**Subject:** Rezoning Petition Review

**Date of Review:** April 28, 2022

**Rezoning Petition #:** 21-264

**Location of Property:** Approximately 4.7 acres located on the north side of Oak Dr, east of Old Statesville Rd and south of Pete Brown Rd.

SHEET DESCRIPTION: CONDITIONAL USE PLAN
 C-1

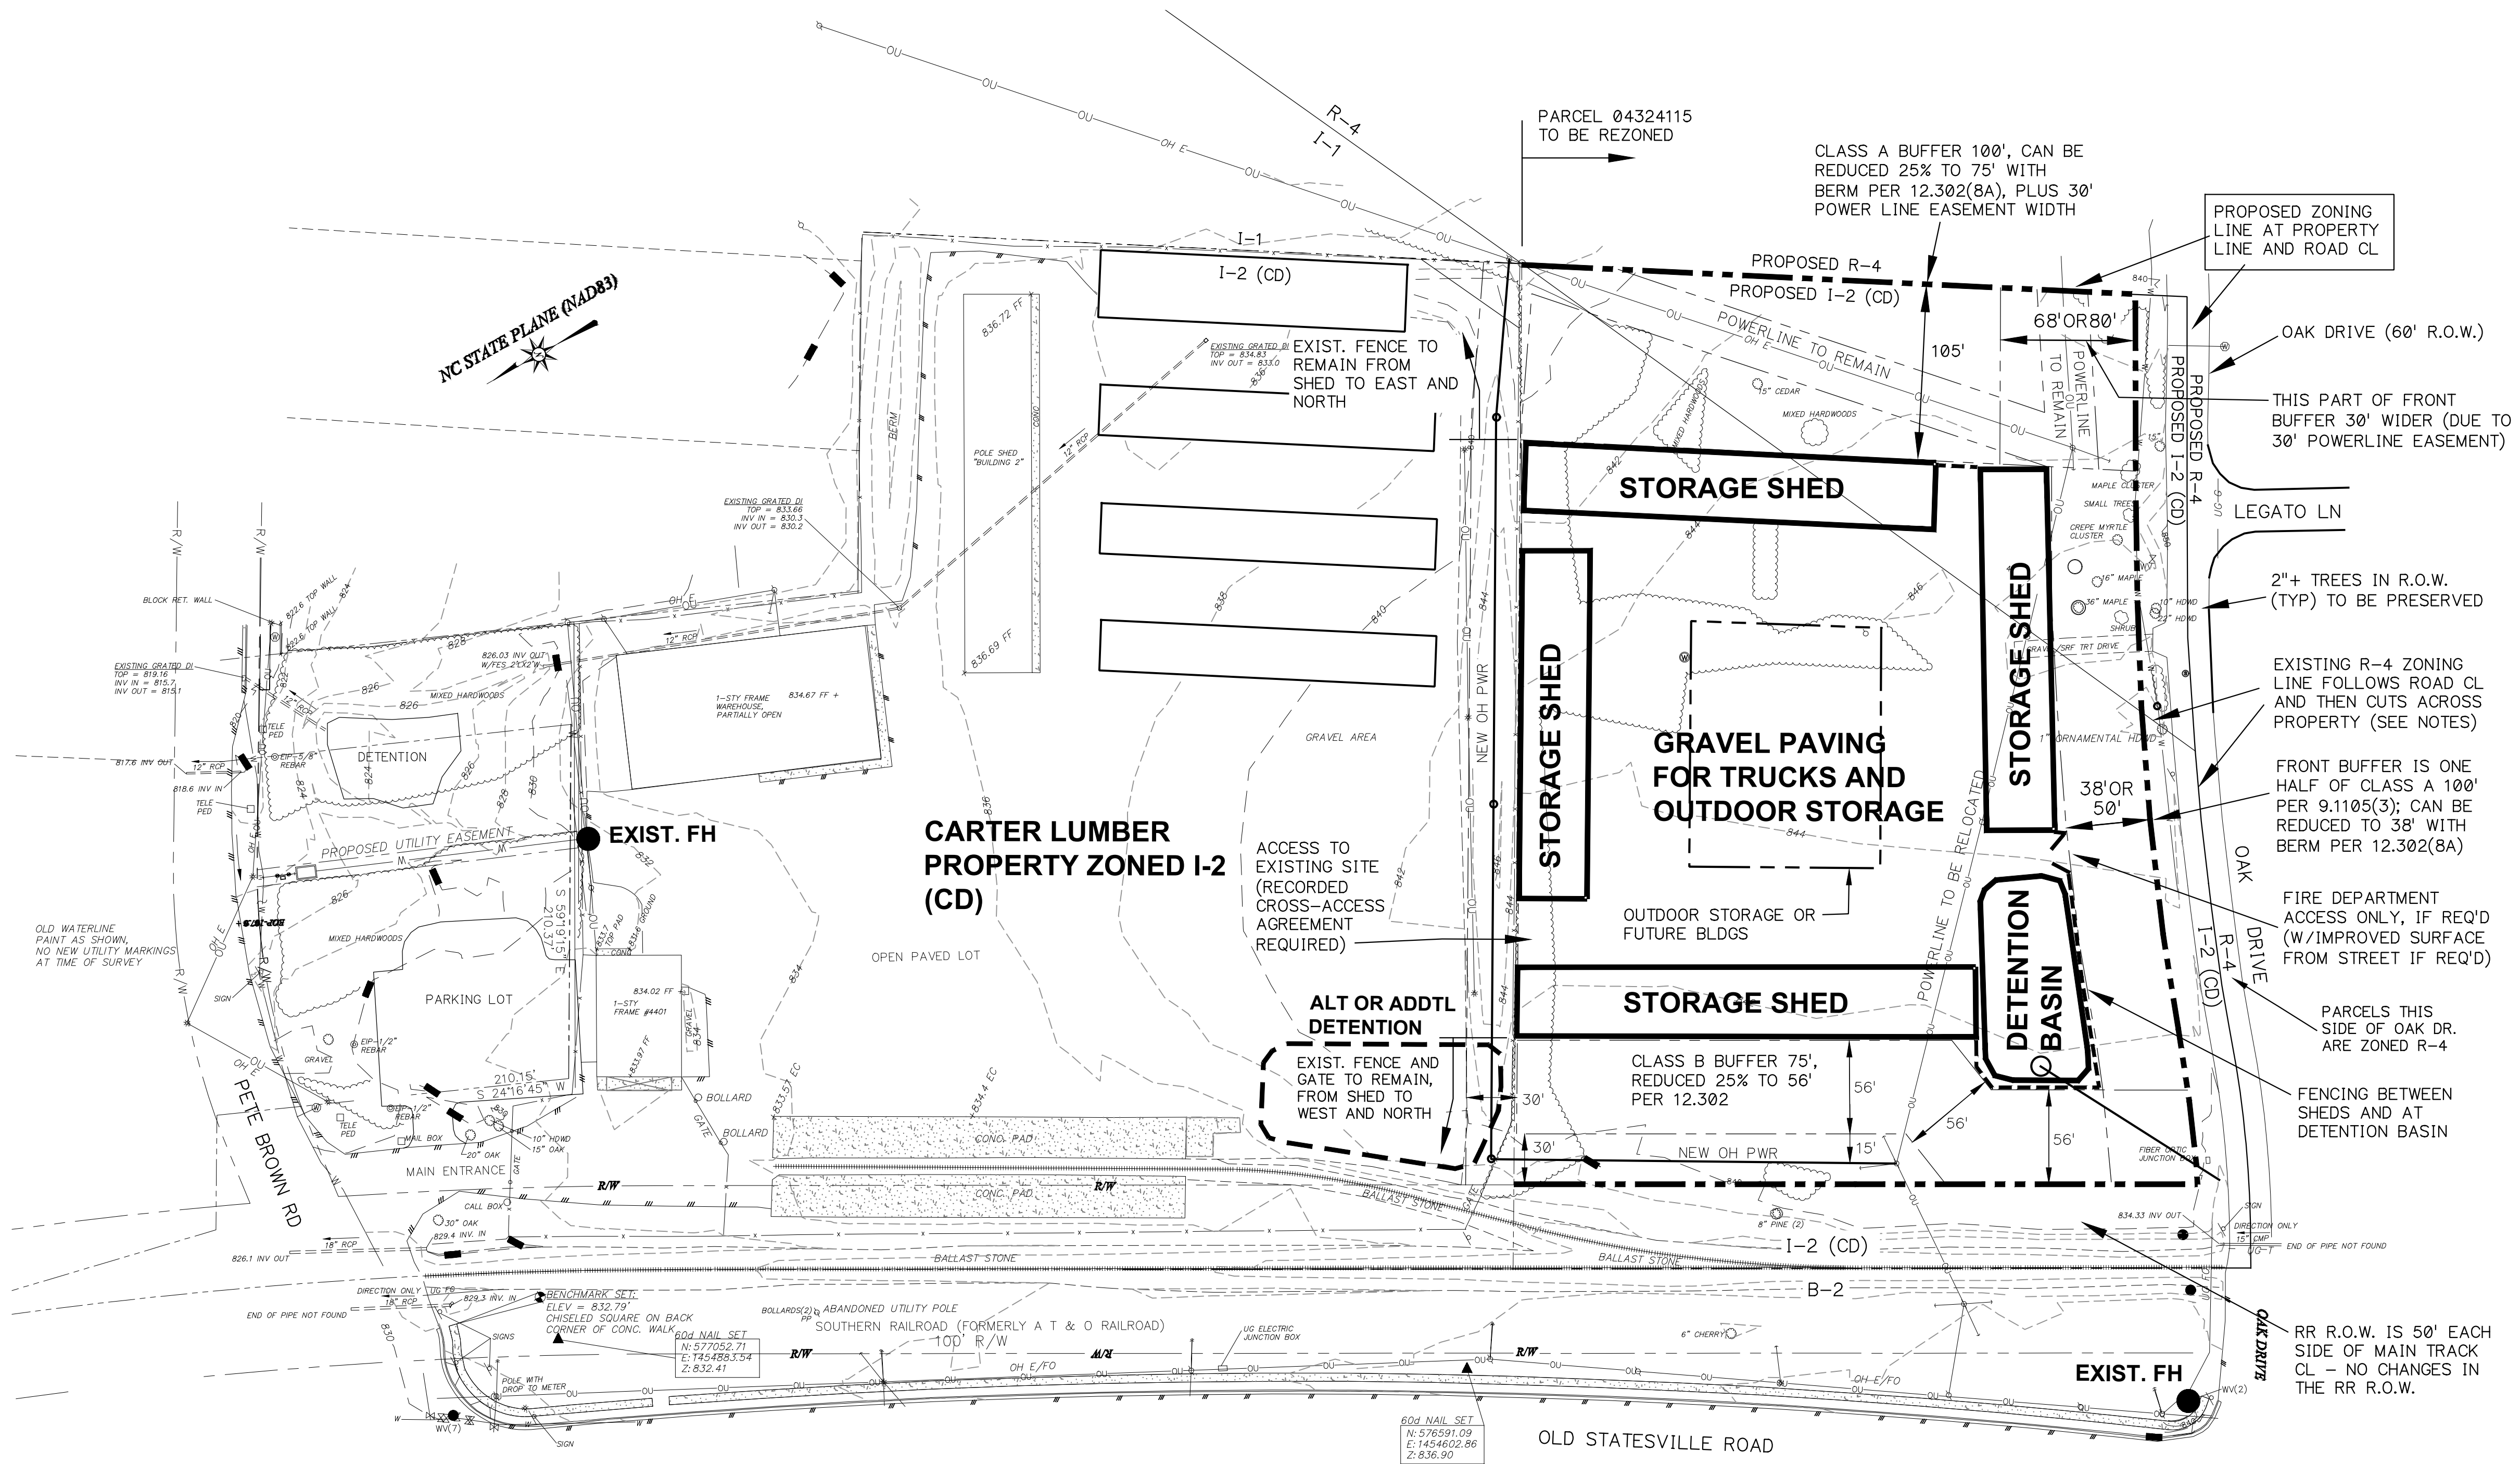
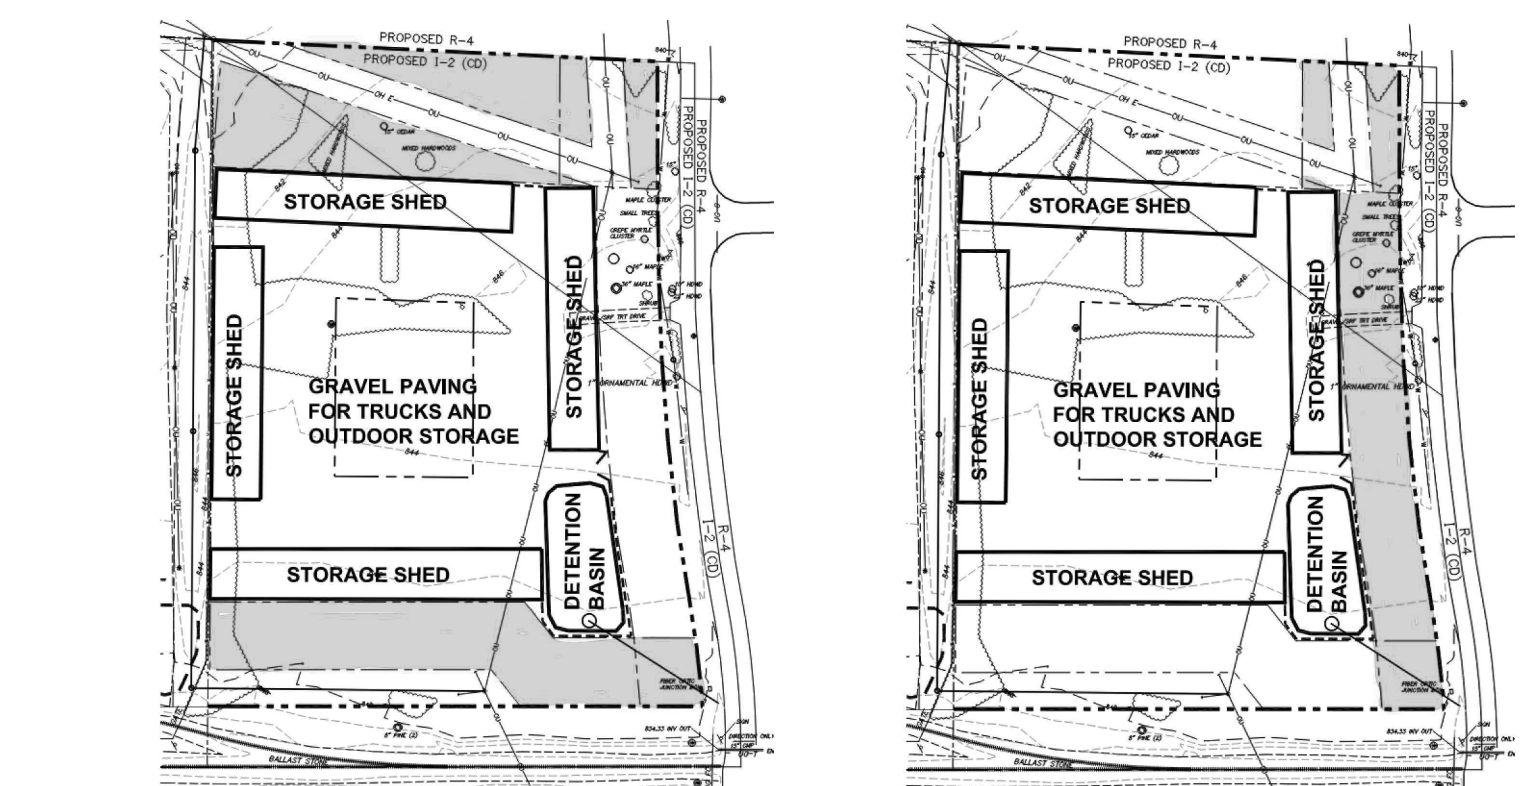
The proposed rezoning plan sheet indicates a proposed location for storm water management. Please include the following notes on the plan sheet under "Environmental Features": *The location, size, and type of storm water management systems depicted on the Rezoning Plan are subject to review and approval as part of the full development plan submittal and are not implicitly approved with this rezoning. Adjustments may be necessary in order to accommodate actual storm water treatment requirements and natural site discharge points.*

**This property drains to Mallard Creek, which is an impaired/degraded stream, and may contribute to downstream flooding. This project has the opportunity to mitigate future impacts to this stream, therefore, Storm Water recommends placing the following notes on the plan:**

(I) Storm Water Quality Treatment

For defined watersheds greater than 10% built-upon area (BUA), construct water quality stormwater control measures (SCMs) designed for the runoff generated from the first 1-inch of rainfall for all new and redeveloped BUA associated with the project. SCMs must be designed and constructed in accordance with the Charlotte-Mecklenburg BMP Design Manual.

(II) Volume and Peak Control

For defined watersheds greater than 10% built-upon area, control the entire volume for the 1-year, 24-hour storm for all new and redeveloped BUA associated with the project. Runoff volume drawdown time shall be in accordance with the Charlotte-Mecklenburg BMP Design Manual.

For commercial projects with greater than 10% BUA, control the peak to not exceed the predevelopment runoff rates for the 10-yr, 6-hr storm and perform a downstream flood analysis to determine whether additional peak control is needed and if so, for what level of storm frequency, or if a downstream analysis is not performed, control the peak for the 10-yr and 25-yr, 6-hour storms.
